PLANNING CONSULTATION RESPONSE

Application No	2026/0132
Proposal	2026 0132 LBC Removal and Replacement GF Wall & Removal of Internal FF Flue Far Westhorpe Farm Halifax Road Penistone
Address	Far Westhorpe Farm Halifax Road Penistone
Date of Consultation Reply	26.03.26
Consultee	Tony Wiles Senior Conservation Officer

**Figure 34 (top)** - plan at first floor level showing the location of the additional brickwork flue to be removed.

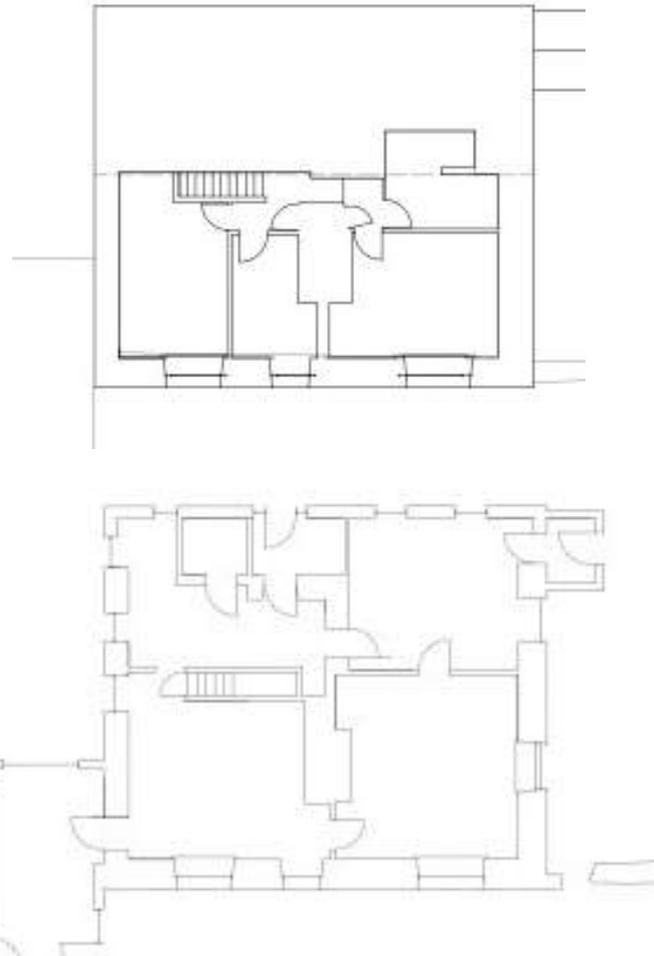
The downstairs wall is tightly positioned beneath an oak beam that supports the floor joists. Made of thinly bedded sandstone, it has a noticeably narrow cross-section and lacks strong lateral support, with only informal restraint at the top where it meets the beam. This wall seems to have been built more recently and belongs to a different construction phase than the original structure. The main reason for considering its removal is the threat of collapse, as it could easily be pushed over due to insufficient restraint. Nevertheless, the wall may hold heritage value and removing it may cause minor harm. Overall, I believe this minimal impact is outweighed by its limited significance and the necessity of ensuring safety.

Regarding the first-floor flue, this has also clearly been retrofitted, with the stonework not bonded into the adjacent wall. The flue serves the downstairs southern fireplace, but at first floor ceiling height the flue terminates and steps sideways connecting into the original chimney to the north. The fire surround at ground floor includes a cracked lintel and appears somewhat less finely finished to the fireplaces on the northern side. On the reverse side of the party wall, there are ground and first floor fireplaces that vent into the stack. This arrangement suggests the southern fireplace and flue were inserted at a later date. The GF fireplace remains in situ, but the flue at first floor level has been removed, with stonework salvaged and palleted. I understand this work was undertaken due to very real concerns for the stability of the structure and recommendations from the Structural Engineer. Whilst it would have been preferable to wait for consent, I accept the justification for the removal as failure could have damaged other structures beneath.
